**WEST SUSSEX COUNTY COUNCIL
STRATEGIC PLANNING CONSULTATION**

SUBJECT: EP/25/13/DOC- Application for approval of details reserved by conditions 3 (materials), 6 (visibility splays) & 8 (cycle parking) of previously approved planning application EP/5/12.

16A, The Nookery, East Preston, West Sussex, BN16 1PT

Proposed site plan

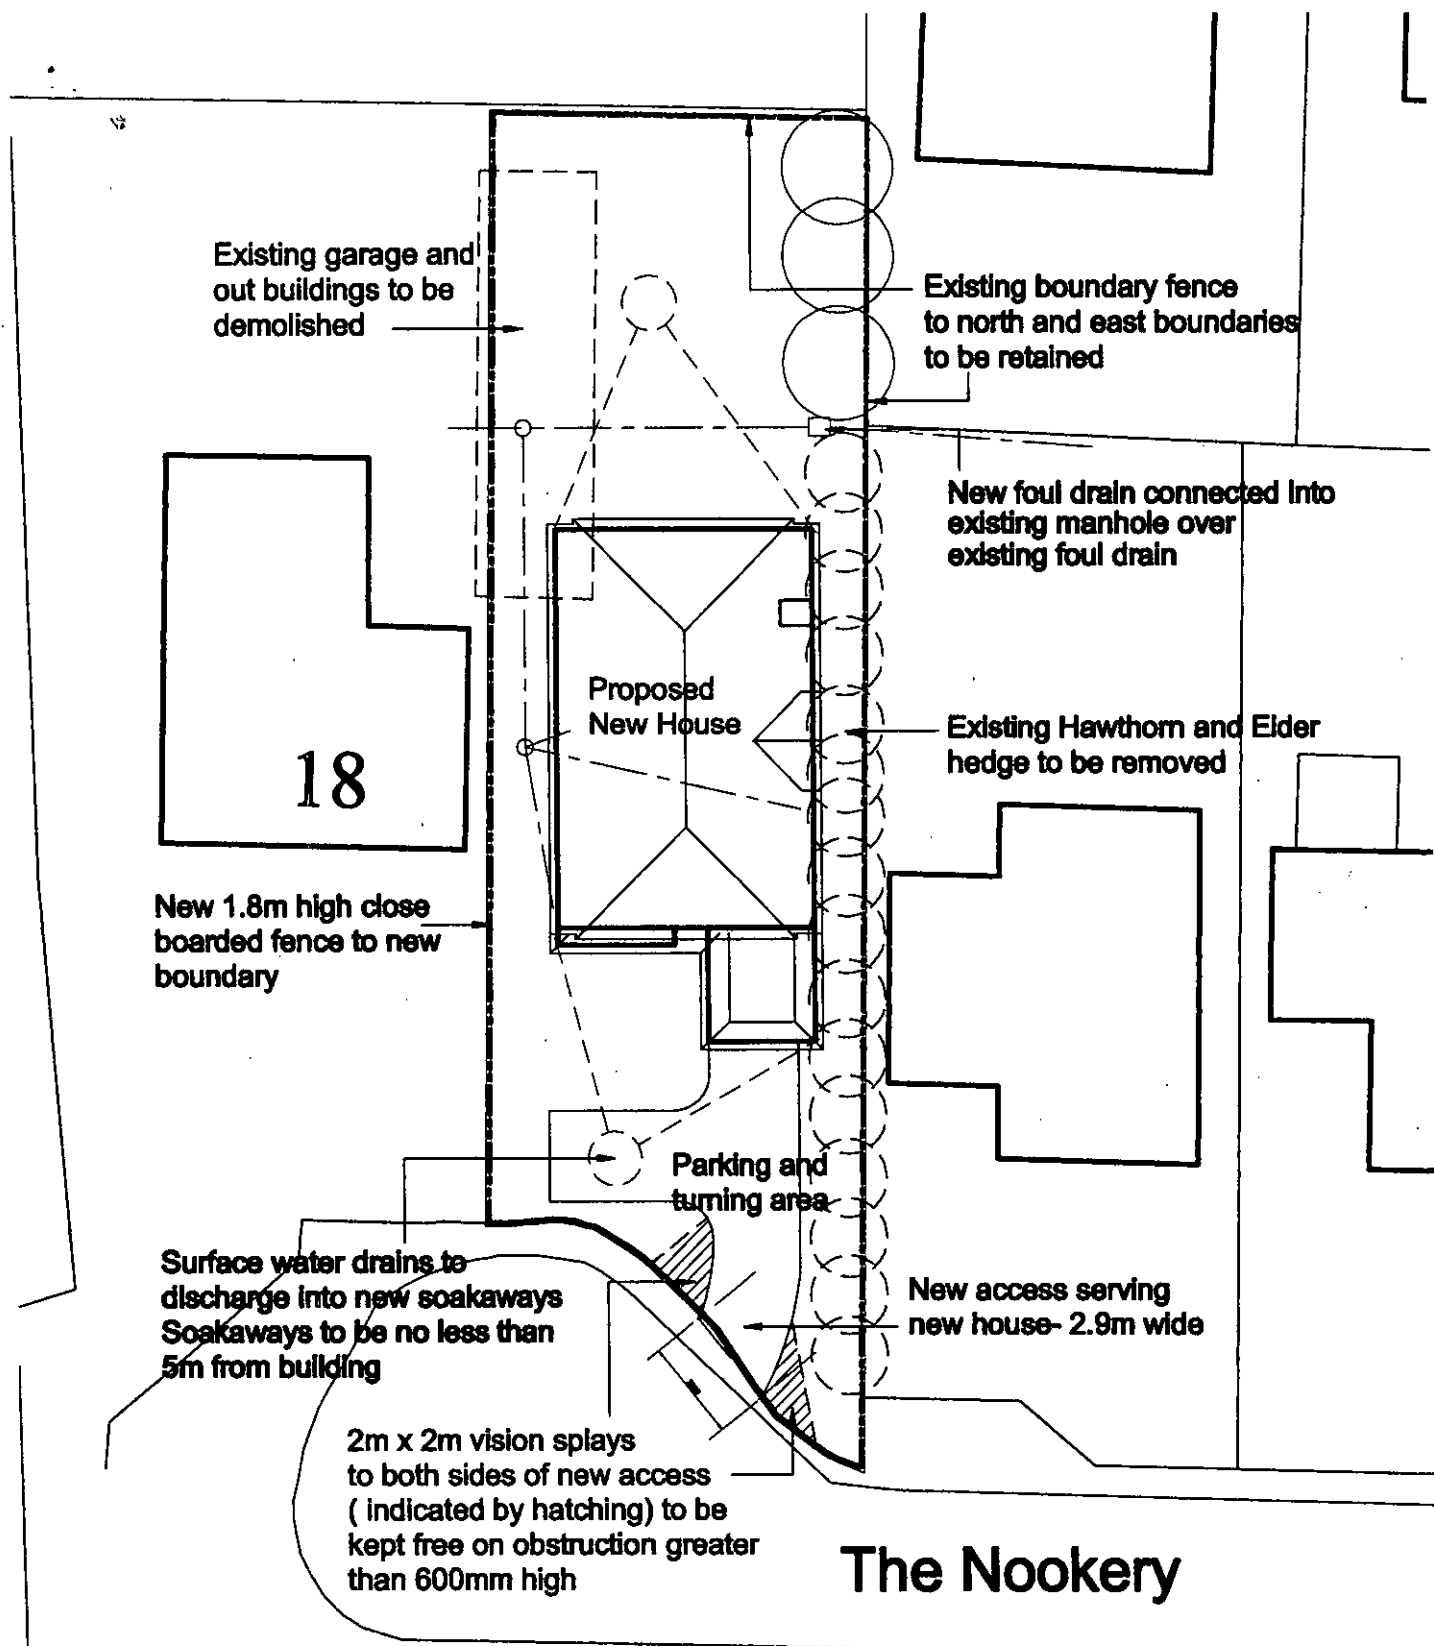
Condition 6 related to access width and pedestrian visibility splays: The access is stated at 2.9 metres, this is considered acceptable and the pedestrian visibility splays are shown to an acceptable standard.

Condition 8 shows cycle parking to an acceptable standard in a secure and covered shed. This is considered acceptable.
